Subject: RE: Land off Arundel Road

Subject: Land off Arundel Road

Thank you for the revised set of plans, and there have been some positive changes added such as the increase central POS, emergency access and natural surveillance provide by some houses to the sports pitch. We still have some significant concerns raised previously that have not been addressed by the revised pack and we still hold the position that the current proposal is of poor design. The approved Design Code is central to the design of this RM submission, and as per the wording of Condition 5 “development shall be carried out in accordance with the approved design code”. The current submission fails to adhere to this condition, with the following primary concerns still not being addressed:

984ft² 91.39m²
Elevation Code B1
Date: May 2019
EF_LETC_SM.5_Rev B

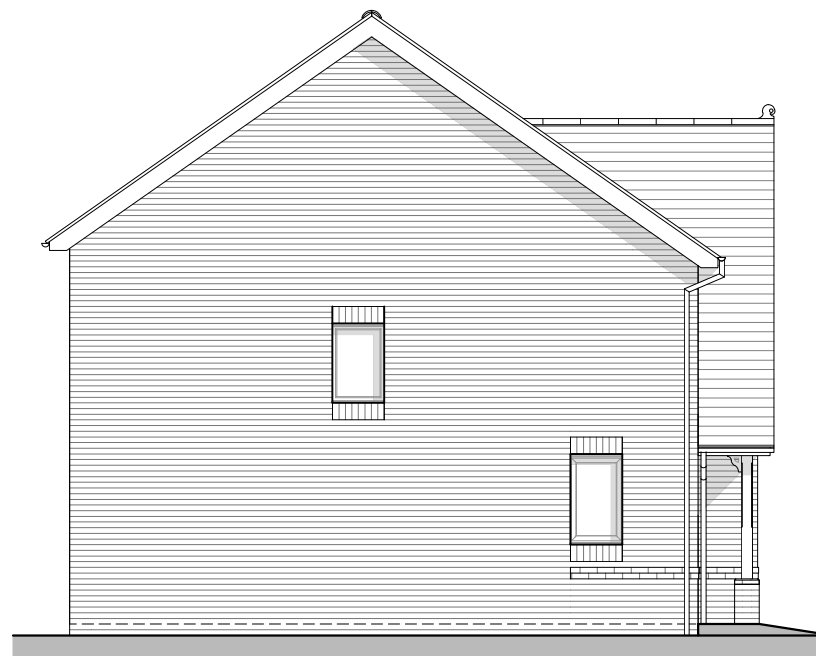
- Four dwellings now face the sports pitches, however more could be done to provide natural surveillance to this area.
- The use of white cladding is still evident, and has not been removed from the scheme. The parish council have also raised whether the dark mock Tudor style gables are characteristic of the area. There is no evidence to show that this choice of material and design is appropriate for this locality. We would seek the development to reflect the context of Angmering, rather than off the shelf-designs.

We previously raised concern with some of the material choices, these have not been revised. The use of white cladding, and mock Tudor external finishes are not characteristic of the area, and are therefore unacceptable for this locality.

Title **Planting Plans**
6 of 6

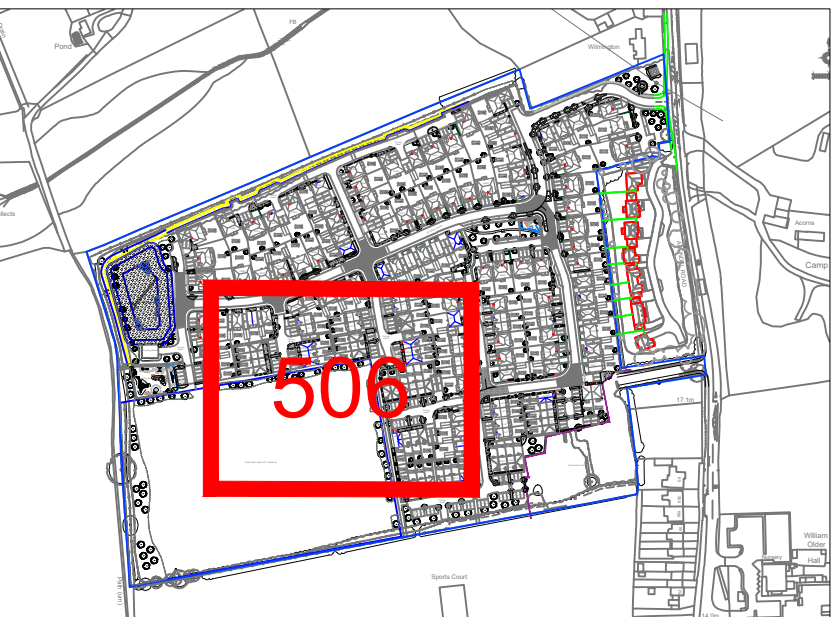
- Whilst there has been some change to the spread of affordable housing, it is still clustered and confined to the higher density areas.
- There are still areas which do not accord with the design in respect to the green corridors, some areas have been improved but overall the landscaping has not gone far enough to reflect the requirements. Also, the planting scheme is reliant on tree planting within private garden space.

The Design Code Masterplan shows green corridor route throughout the site, however this has not been full reflected within the revised layout. There is some tree planting within front, and most rear gardens of the private dwellings, there is no insurances that these will be retained and maintained. Planting and landscaping should be increased through the green corridors and within the public realms.

Density plan

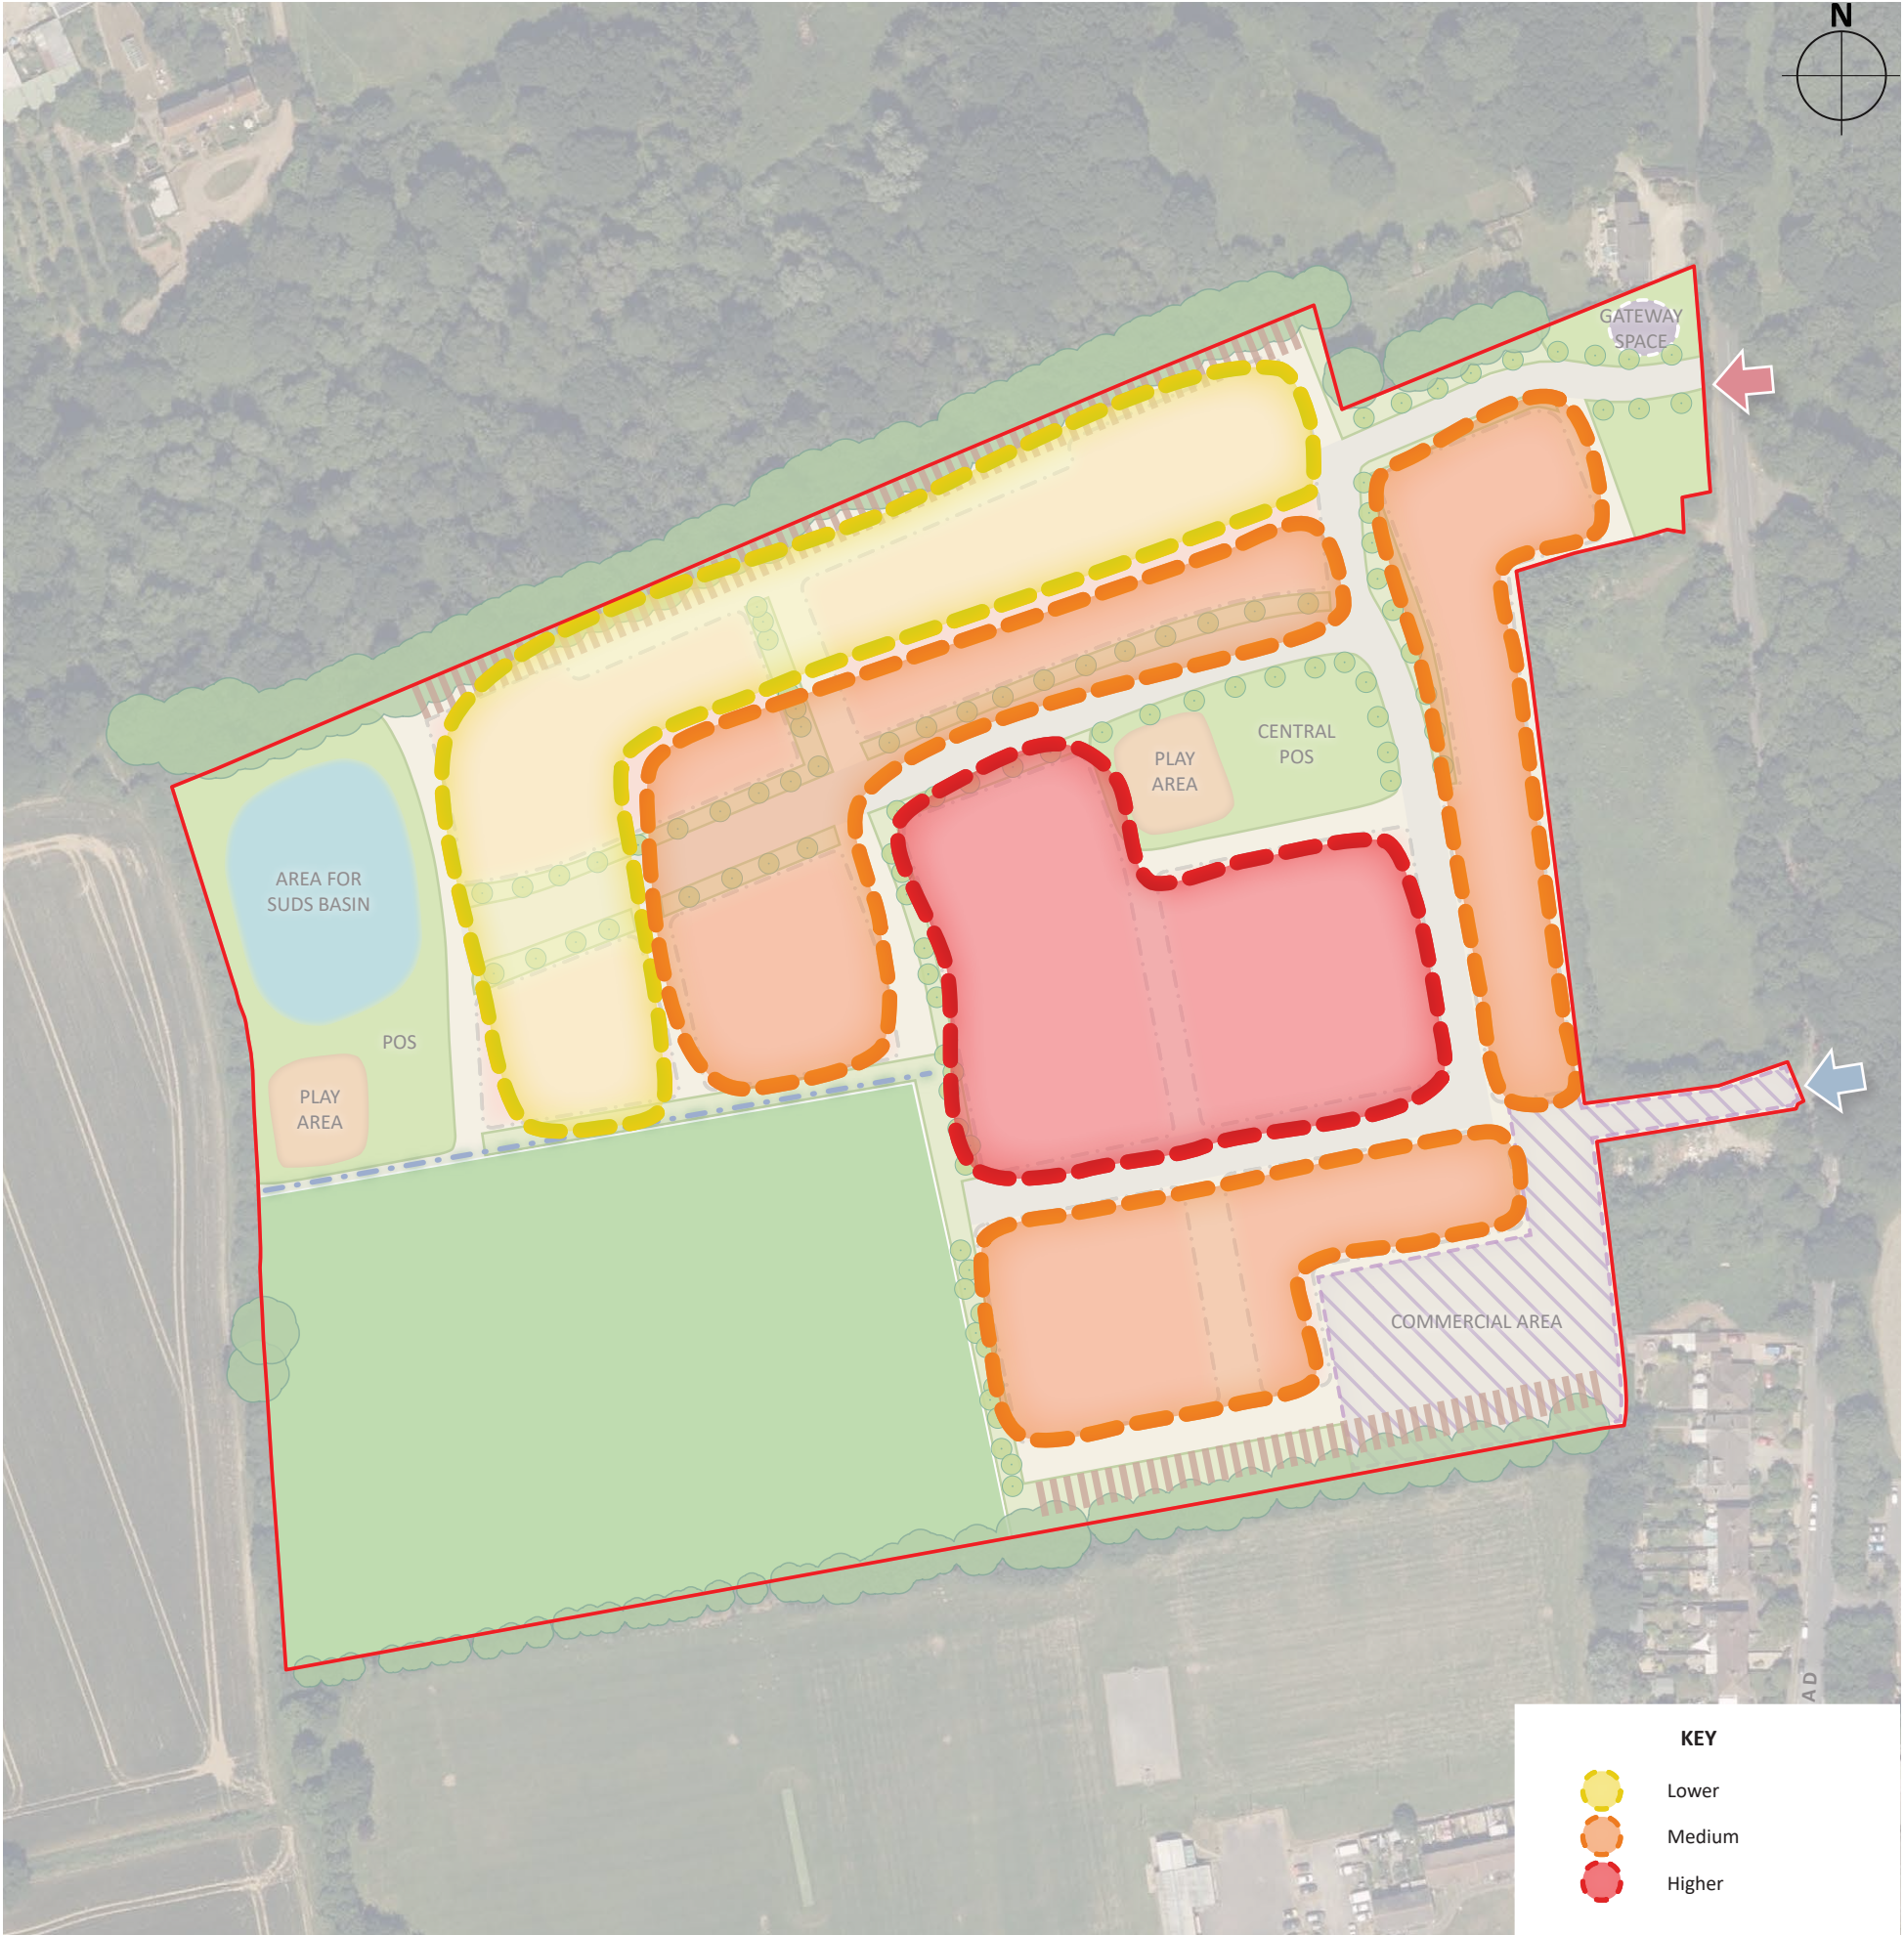
- The density does not reflect that within the approved design code, with the high density around the southern edges of the site, rather than more centrally. Justification has been provided for the housing mix, however it still significantly deviates from the SHMA. The poor housing mix has led to a cramped development that is overly car dominant as seen by the poor parking arrangements, particularly in the southern half of the site. The scheme is extremely car parking dominant, with some roads being characterised by parking forward of the dwellings front elevations. For example, the road serving the east side of the site has 37 parking spaces at the front of the dwellings, with a further 22 parking spaces forward of the dwellings south of this.

According to the approved design code, the densest part of the development should be within the central part of the site, below the POS. With the medium densities surrounding to the south, east and west, and the lower densities within the north. However, the revised proposed layout shows the highest density throughout the southern portion of the site, with a clear divide of low density dwellings to the north. In turn, this creates issues with the proposed parking arrangements “squeezing” parking forward of the houses front elevations, creating a development that is car parking dominant. For example, between plots 7-23 plus the visitor spaces there are 37 car parking spaces lining the access road, which negatively impacts on the character of the development. The affordable housing is still clustered in the dense southern area of the site, this is not in accordance with Arun Local Plan Policy AH SP2. The proposed density and mix particularly the southern portion is unacceptable and would compromise the amenity of future occupiers due to the cramped nature of the housing and affordable units.
